STATE OF NORTH CAROLINA  
DEPARTMENT OF TRANSPORTATION

**Addendum No. 1**

RE: Contract # C204270

Intersection Improvements (Roundabout) At NC-751 Hope Valley Road  
And SR-1183 University Drive In Durham

STANDARD TEMPORARY SHORING
(SLOPE CASE)
*SEE TABLE ABOVE.

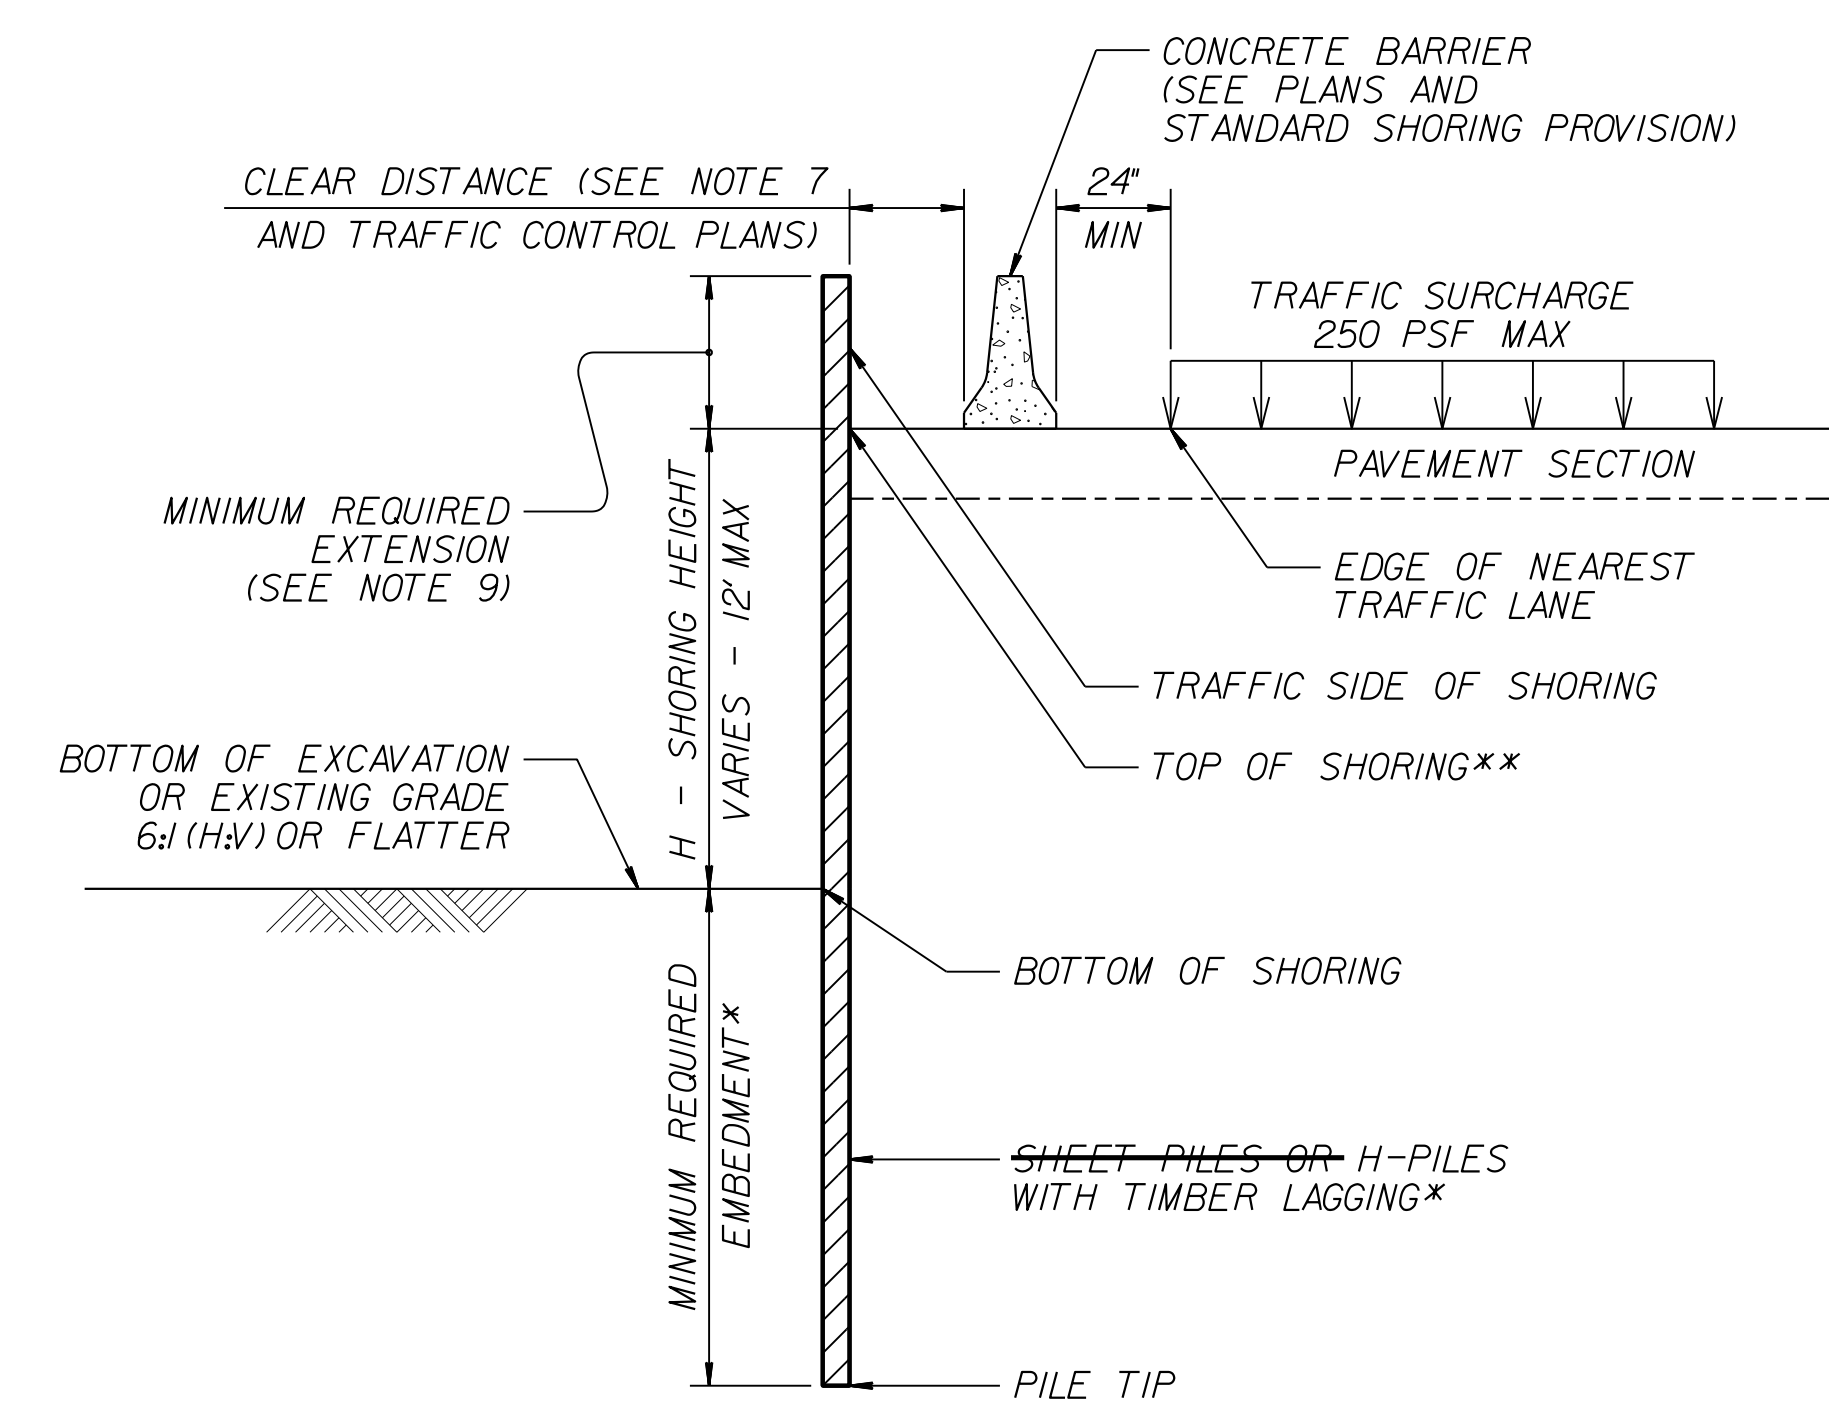
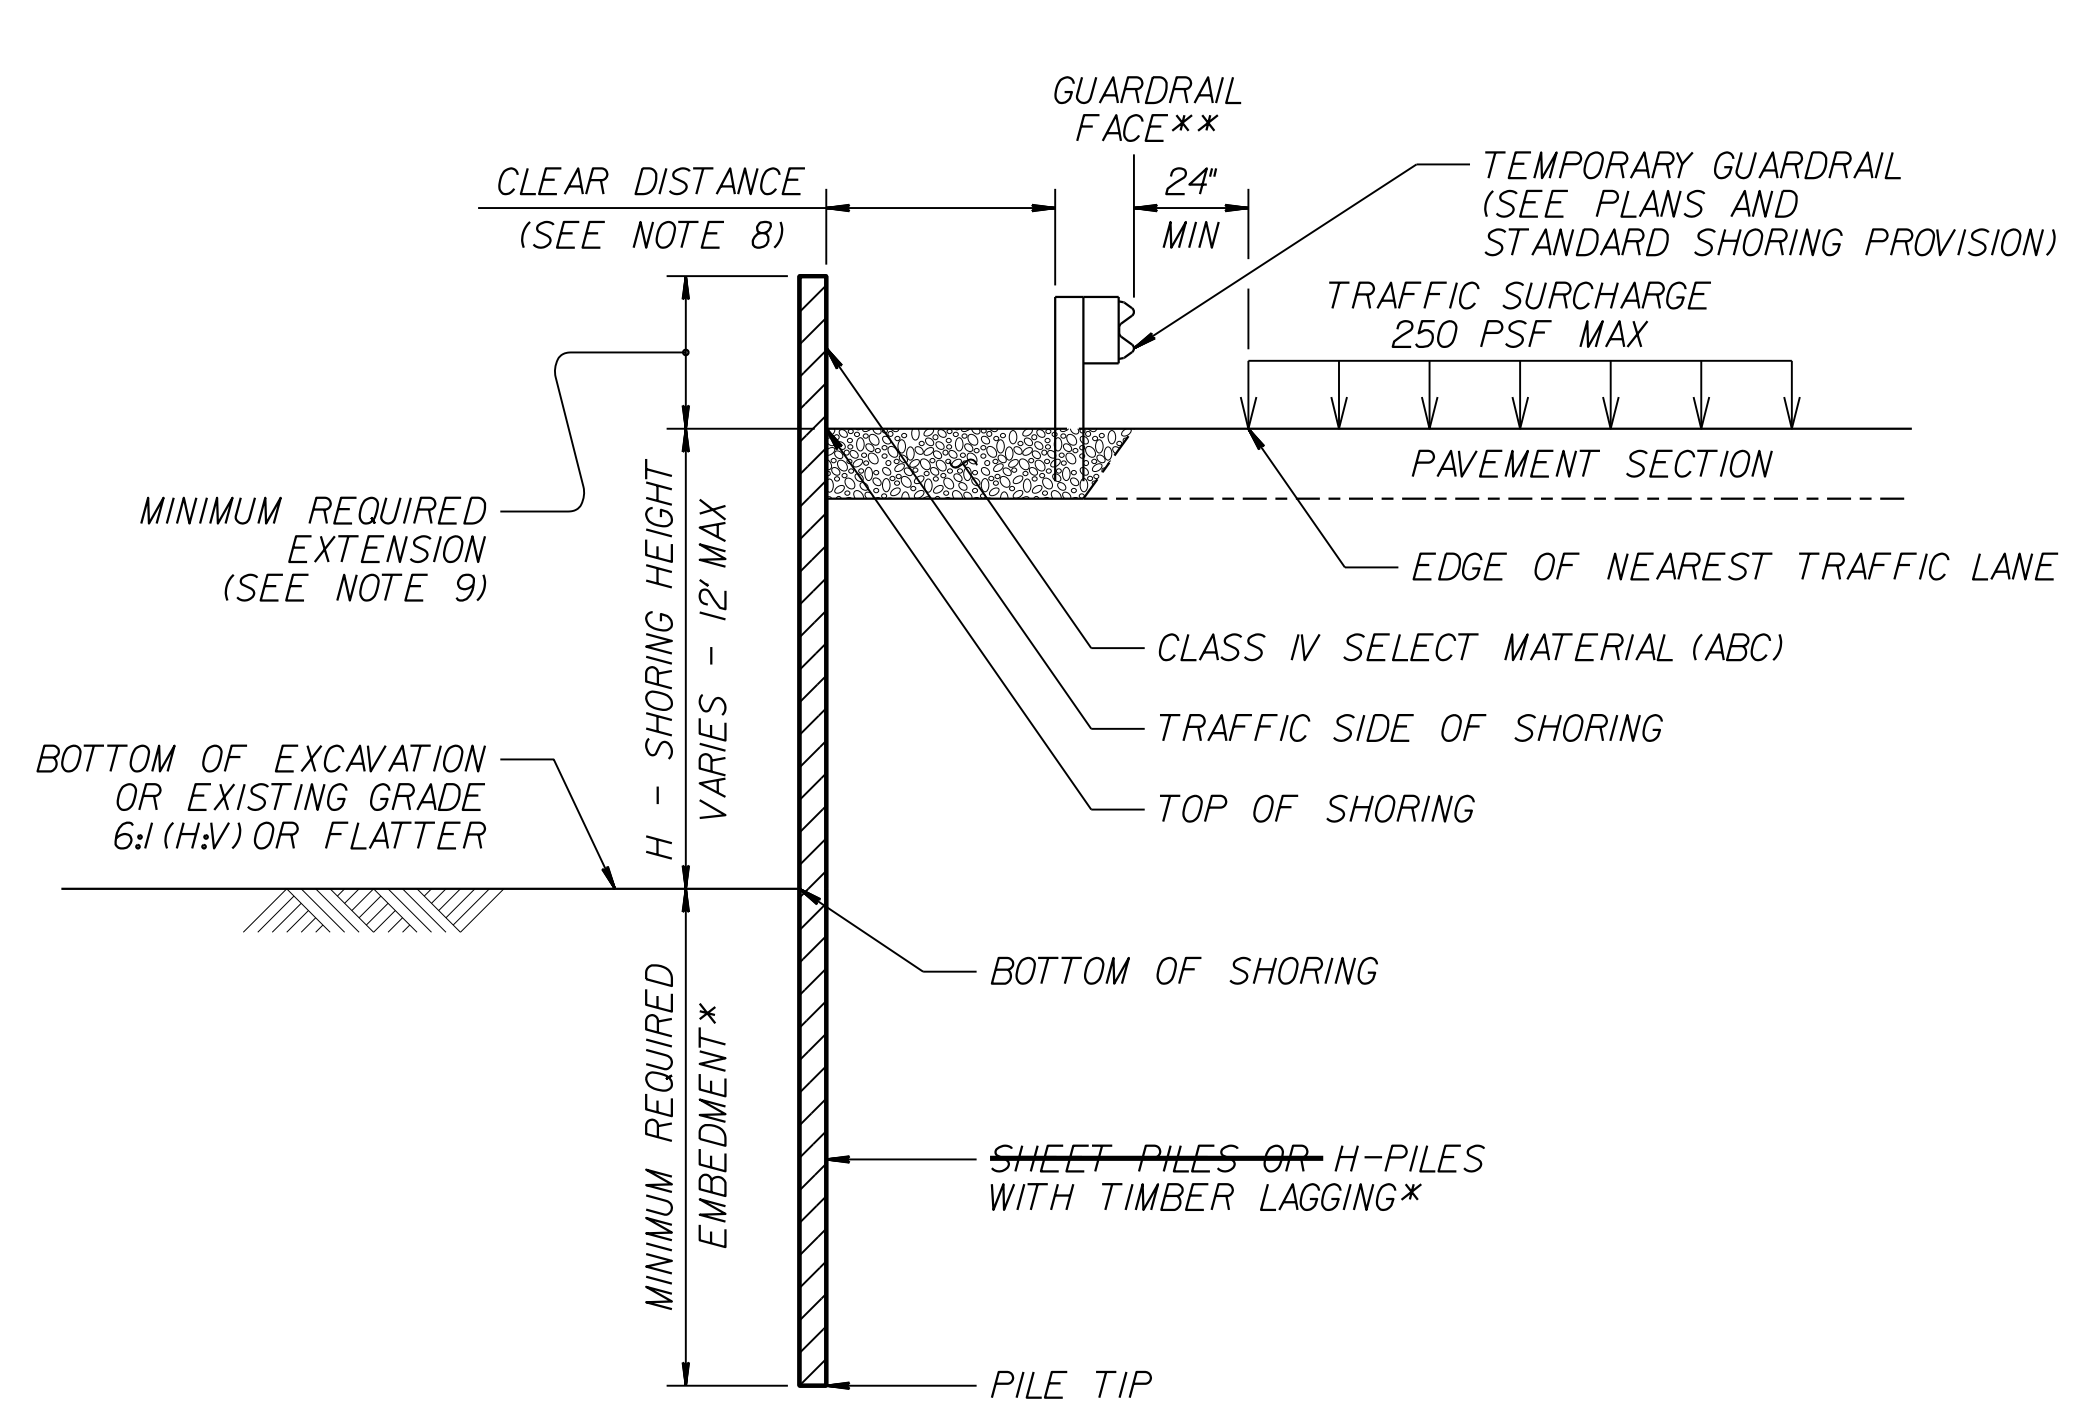
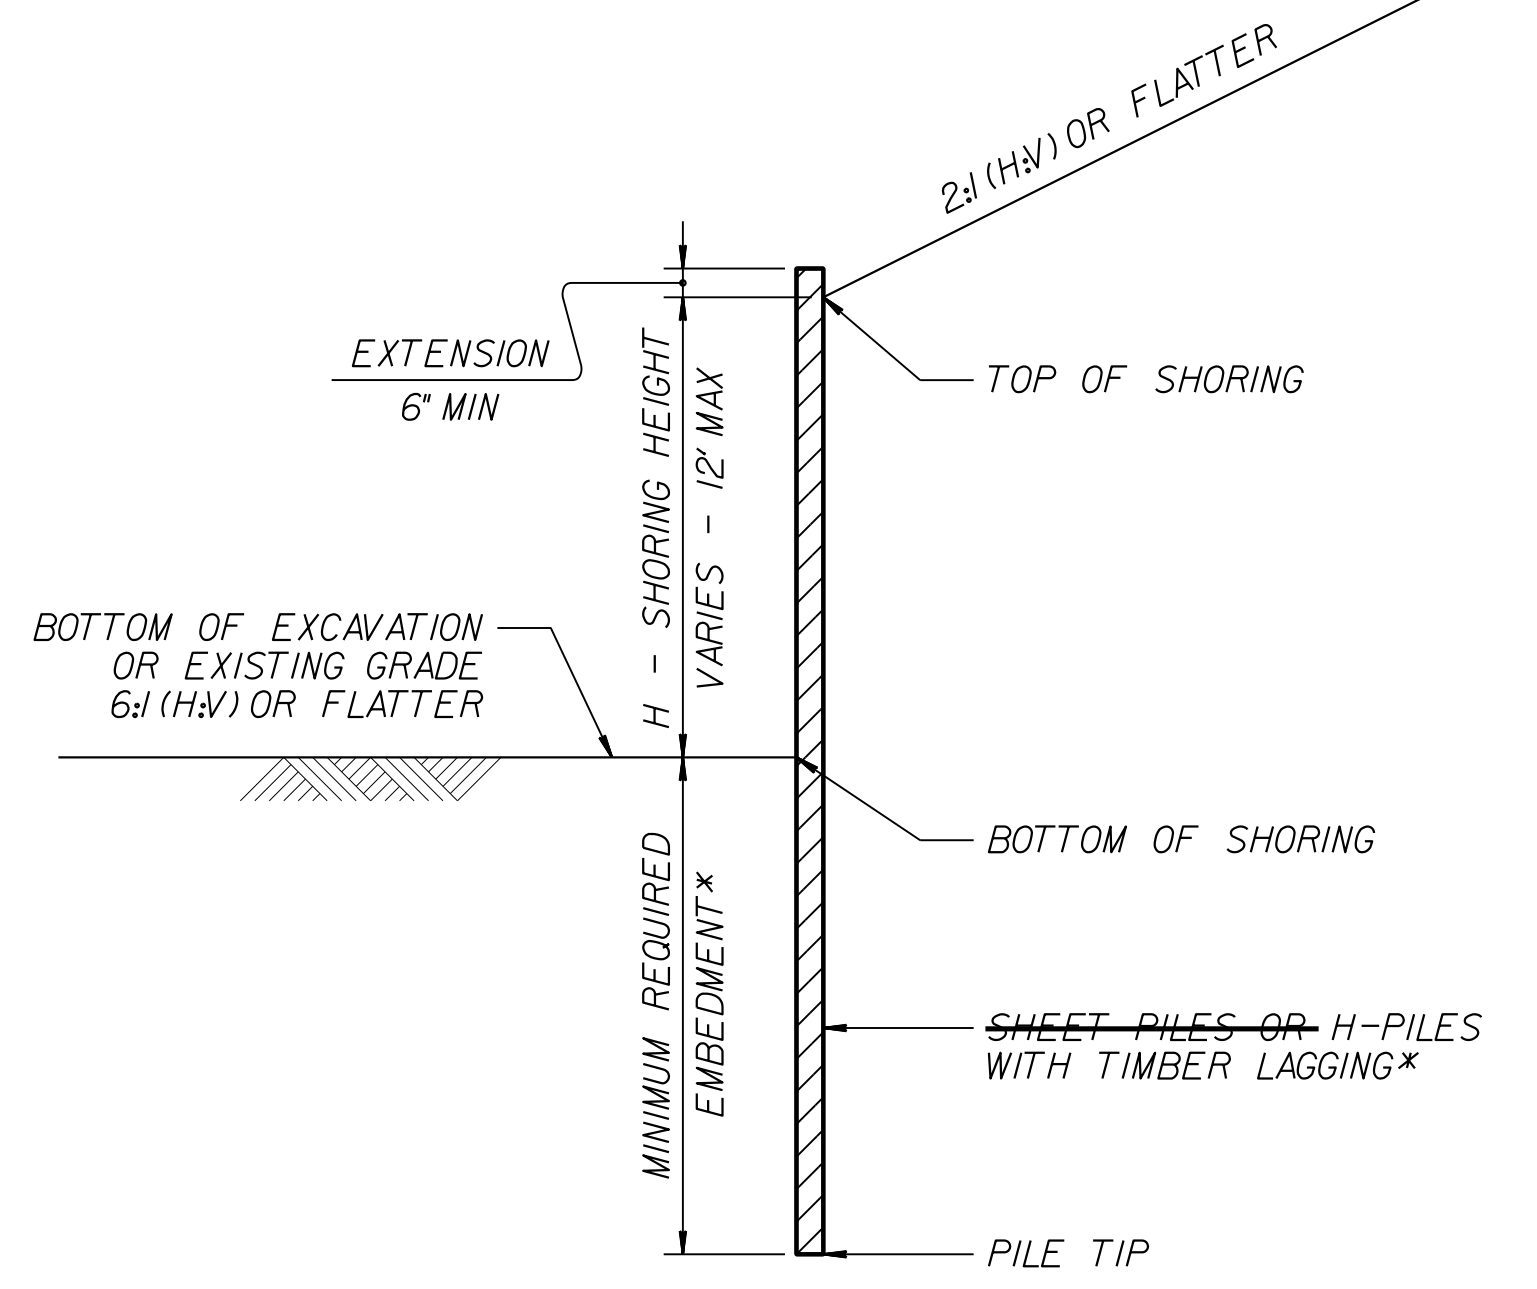
Sheet No.	Revisions
New 2G-1	New Sheet added to include Standard Temporary Shoring detail
UC-3	Revised Note #5 under "Water Relocation"
C-1	Revised "Total Structure Quantities" table to change from "#57 Stone" to "Select Material, Class IV"
C-3	Removed the third note and added notes for the "Temporary Shoring"
